**OXFORDSHIRE COUNTY COUNCIL'S RESPONSE TO CONSULTATION ON THE
FOLLOWING DEVELOPMENT PROPOSAL**

Application no: 14/01366/REM

Proposal: Reserved Matters Application to 10/01642/OUT - Erection of 74 dwellings with associated car-parking, infrastructure and public open space

Location: Former Building 32 & Adj Land At Heyford Park Camp Road Upper Heyford Bicester OX25 5LX

DRAWING TITLE **SITE LAYOUT**

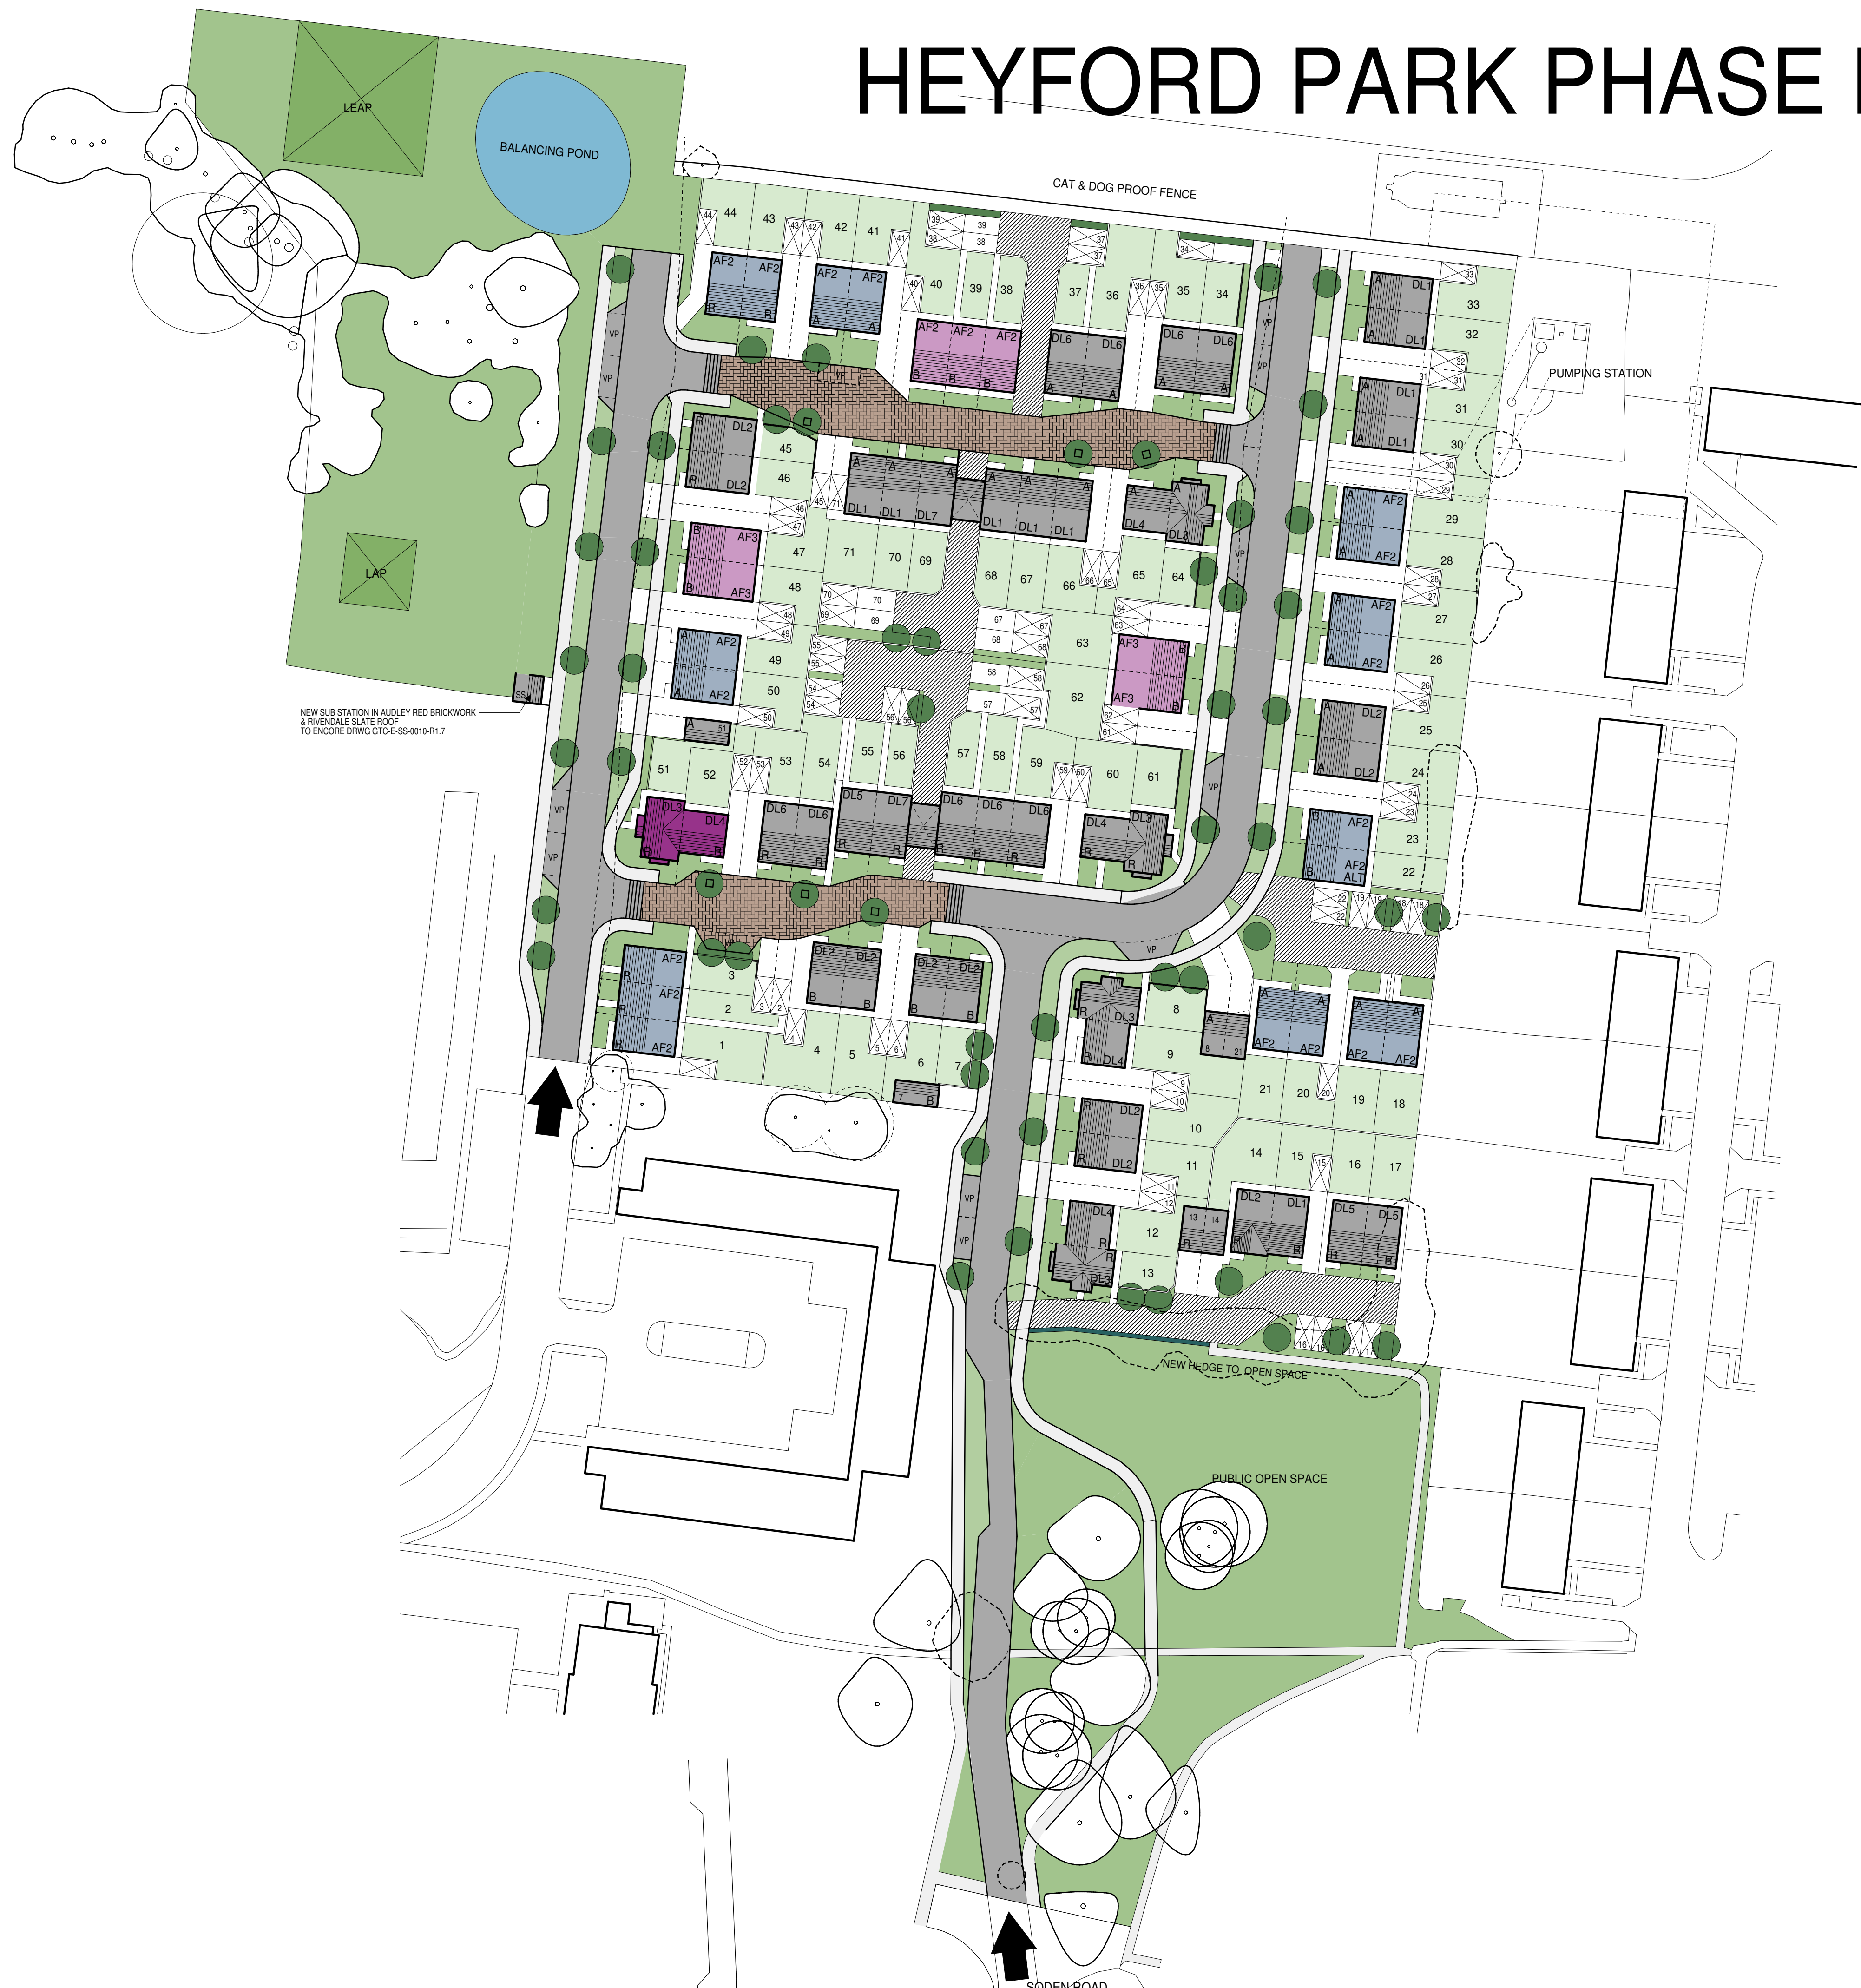
A number of the parking spaces on the private drives on Drawing No.014/085/SP appear to be close enough to the edge of the driveway for it to be not possible to turn and exit the driveway in forward gear. This applies specifically to the following spaces:

- Plot 17 east;
- Plot 18 east;
- Plot 44 north;
- Plot 57 west;
- Plot 61 east.

The site layout will need to be amended such that it is possible for cars at all parking spaces on private driveways can access and egress the estate road in a forward gear. This will need to be demonstrated showing the vehicle swept path of an estate car on a scale drawing. The swept path of a refuse vehicle accessing all areas of the estate road will also need to be shown on the plan.

All parking spaces will need to be provided in accordance with OCC's minimum dimensions. These require a minimum 5.0m in length with width varying from 2.5m to 2.9m depending on obstructions. The spaces on Drawing No.014/085/SP do not appear to conform to these standards.

The key to Drawing No.014/085/SP does not specifically identify a pedestrian footway. However, it is assumed that it is represented by the pale grey area adjacent to the carriageway. This surface does not penetrate the north eastern part of the development site. This arrangement will need to be amended such that all dwellings are accessible to pedestrians via a footway.

The estate road will need to be of a design and layout such that it can be traversed by a standard size refuse vehicle. This will need to be demonstrated by vehicle swept path analysis on a scale drawing.
